Sue Howell
Parks and Greenspace
37943

**RE: PLANNING APPLICATION ICIS BUILDING 35 WORTHING ROAD, EAST
PRESTON LITTLEHAMPTON BN16 1BQ EP/76/12**

Drawing Title
Proposed Site Layout

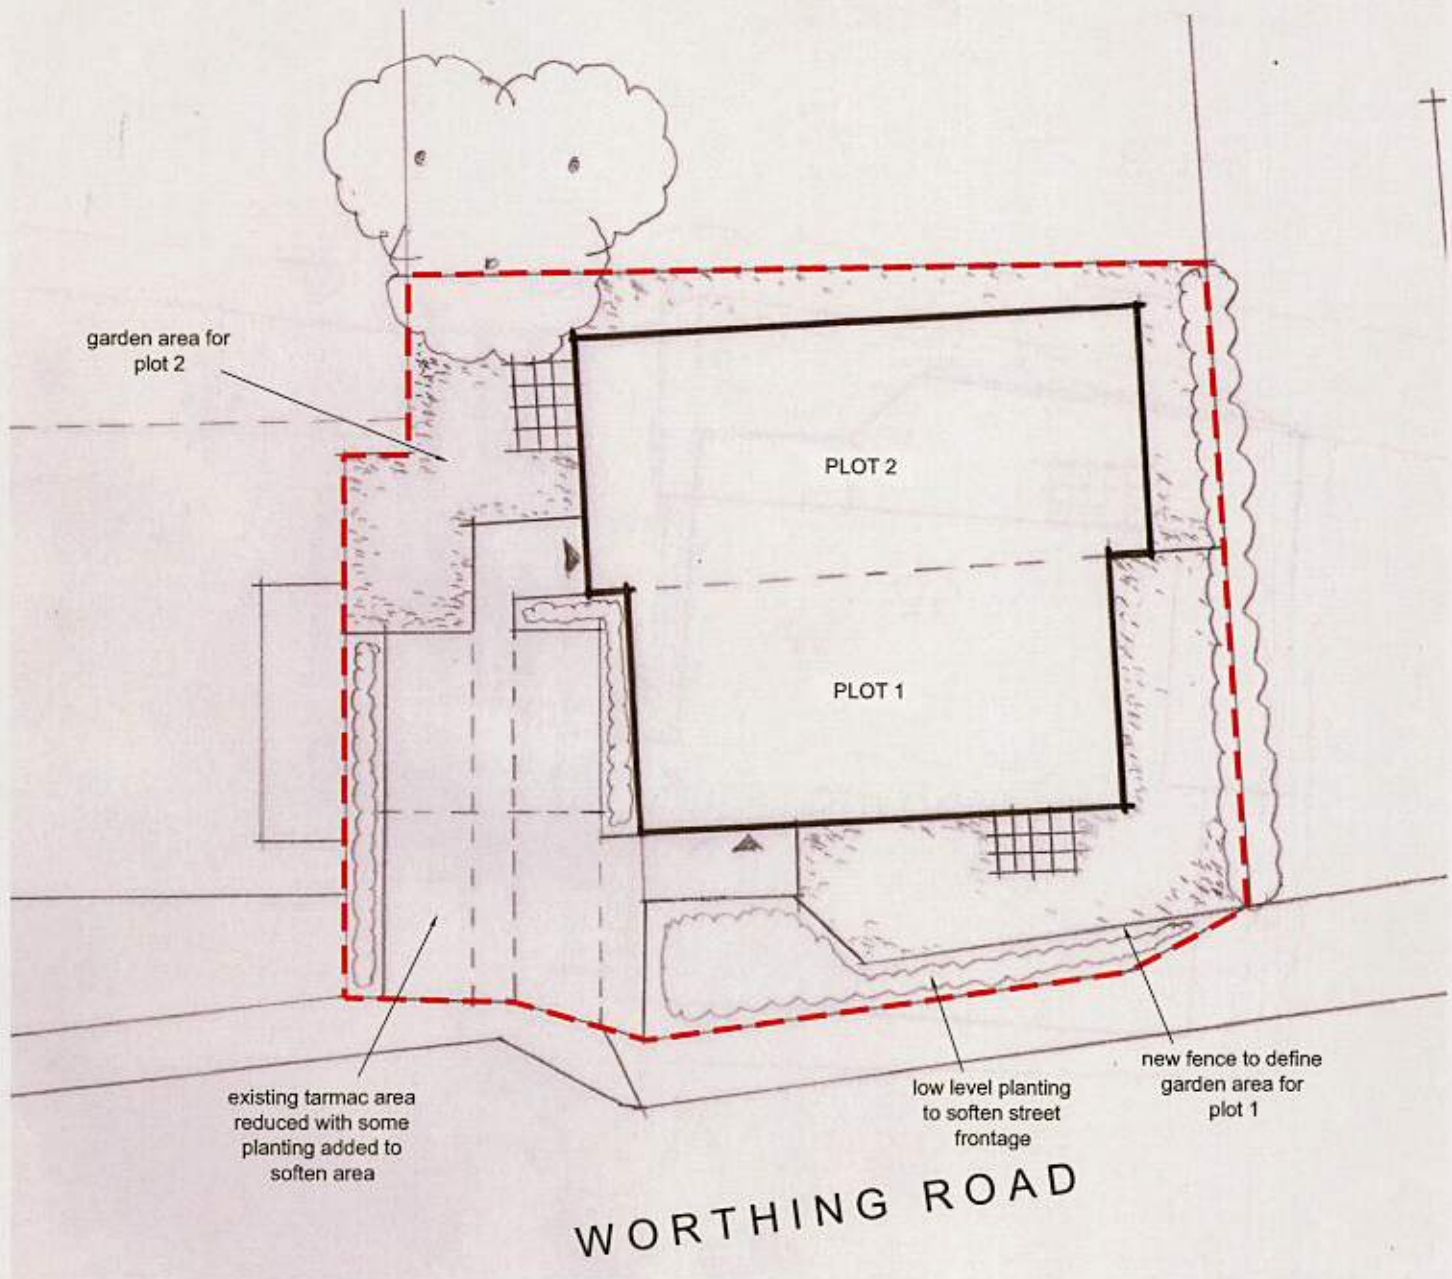
We would however make one point of note that the 'low level' planting detailed to the frontage to soften the street frontage, should be species sufficiently low growing so as not to afford any sight line issues in the future.
